From: Liz Rogers [REDACTED]
Sent: 10 April 2019 11:44
To: Planning.Responses
Subject: RE: Planning Consultation on: CM/13/19/RES

App No: CM/13/19/RES

Address: Mistletoe Farm Horsemere Green Lane Climping BN17 5QZ

Proposal: Application for approval of reserved matters following outline approval CM/37/18/OUT for the redevelopment of site with 2no. 4 bed detached bungalows & associated works

Tree Retention & Protection Plan

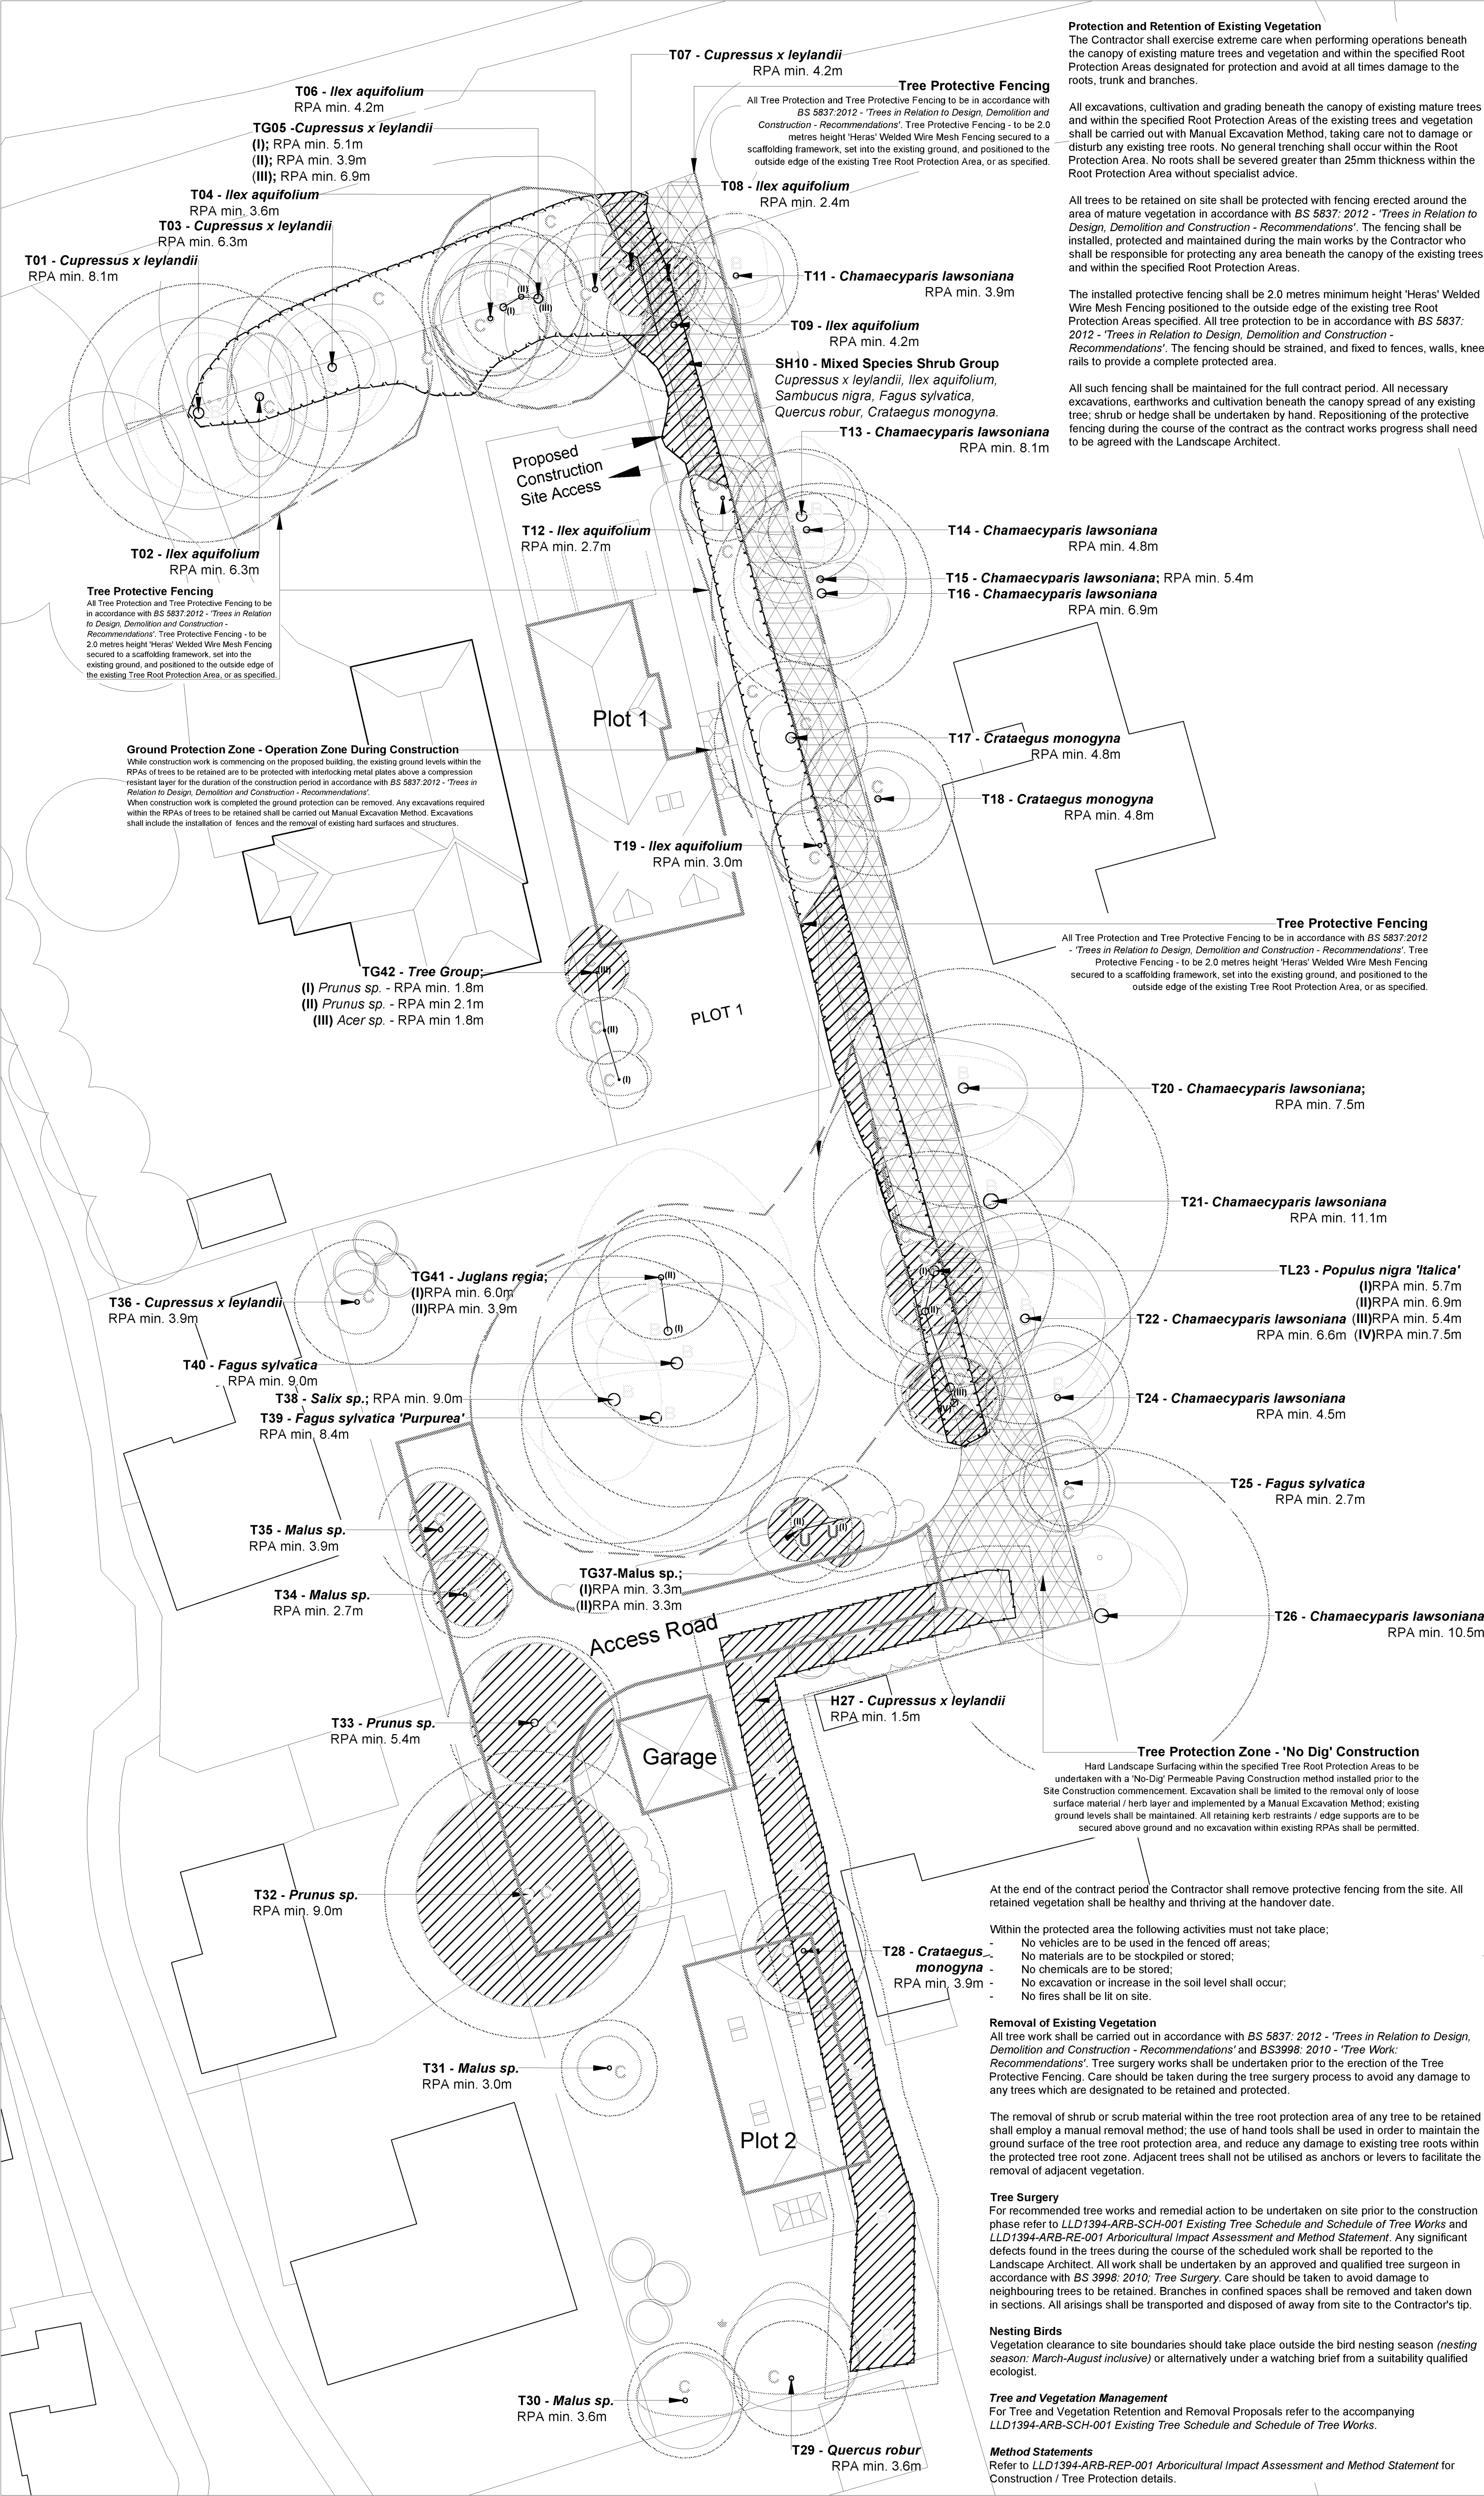
Due to the potential for roosting bats within tree T38, this tree must be retained and protected during the construction works. If this is not possible then further bat surveys on this tree would be required.
